## PROPOSED LIDL FOODSTORE

Former Hayes Pool and Fitness Centre, Central Avenue, Hayes Town

Response to London Borough of Hillingdon Highways Comments

March 2014

| rev | description | date |
|--|-------------|--------|
| 13/0409/TK10 | | C |

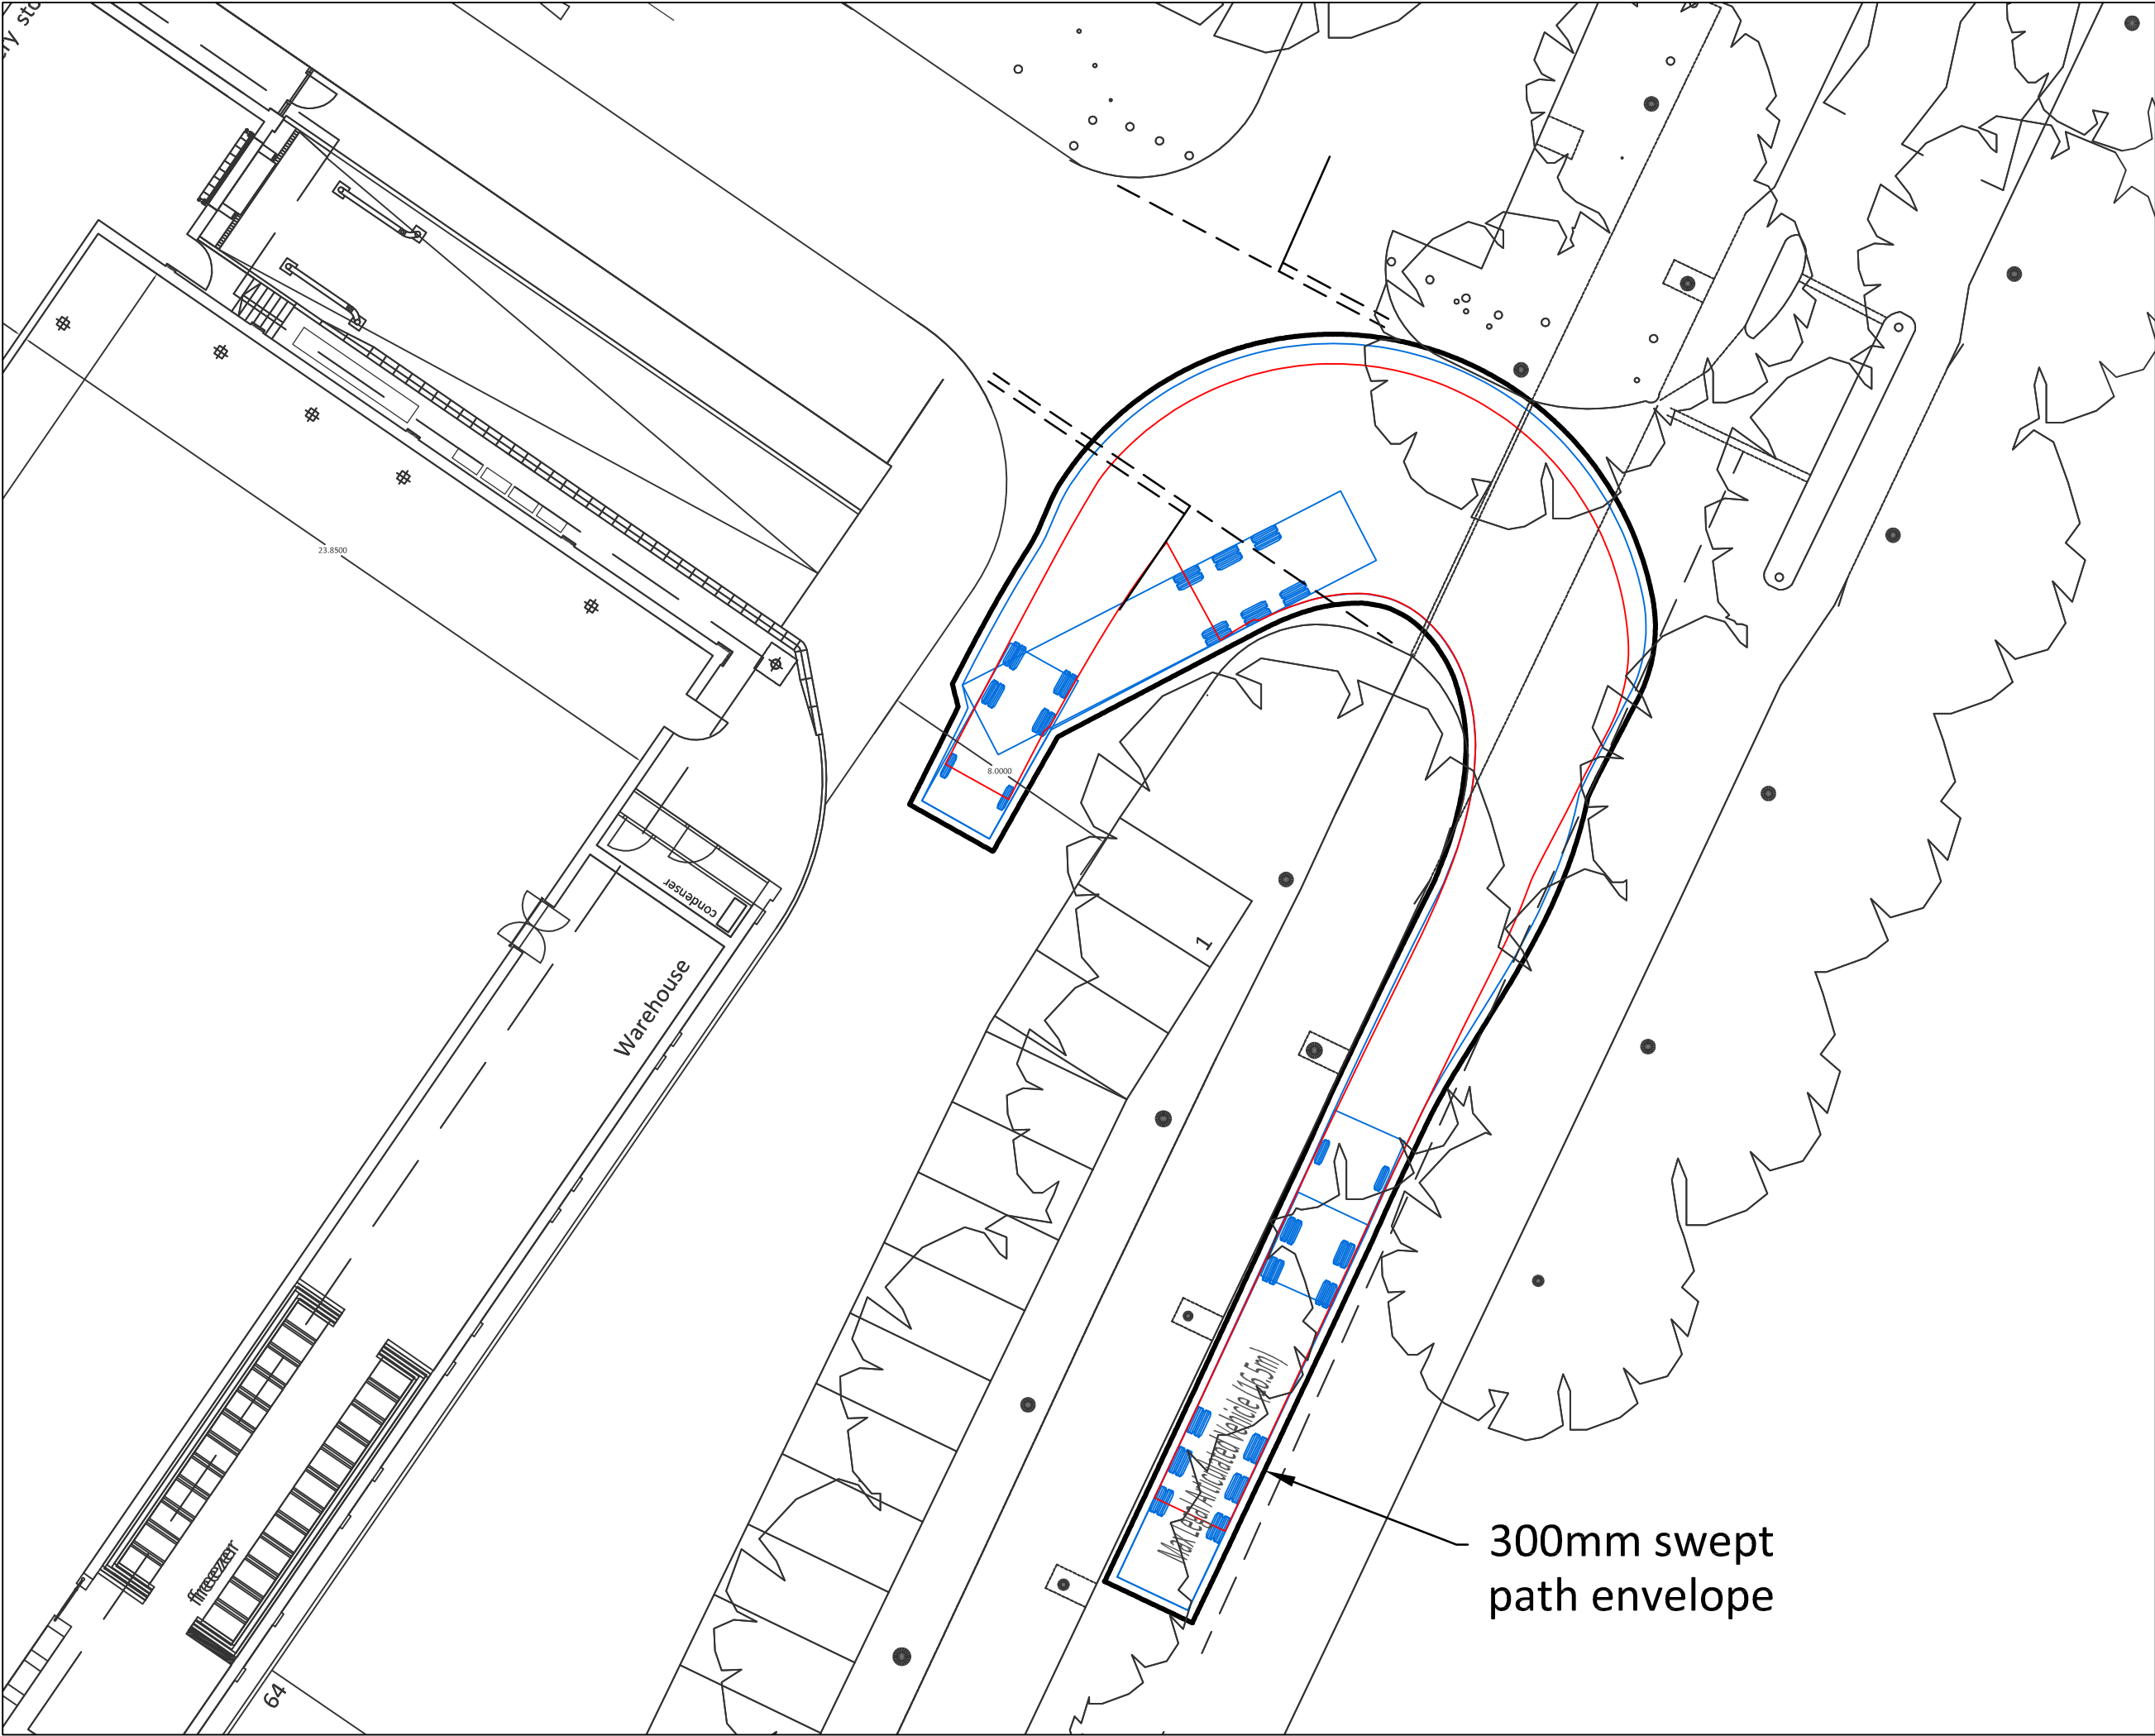
**Swept paths should include a 300mm error margin around the body of the vehicle. This should apply to both delivery vehicles and cars.**

**Notwithstanding the above, the swept paths for delivery vehicles demonstrate that joint access on Central Avenue and the site access both are not suitable for delivery vehicles. The applicant should therefore devise**

**a suitable access design. It should be noted that retail stores of this size and even smaller stores typically have 4-5 deliveries each day.**

- 24** To address this comment, a 300mm margin of error has been drawn around the delivery vehicle on the swept path into and out of the site access junction onto Central Avenue. This updated swept path is provided at **Appendix B**.

- 25** The swept path analysis provided at Appendix F of the Transport Assessment indicates that the site access from Central Avenue can accommodate a 16.5 metre articulated vehicle entering the site, manoeuvring within the site and leaving the site in a forward gear. It is acknowledged that in order to make this manoeuvre the vehicle needs to make use of the full access bell-mouth, but given this is likely to occur 1-2 times per day, predominantly outside of peak operational hours, this is not considered to be unsuitable.
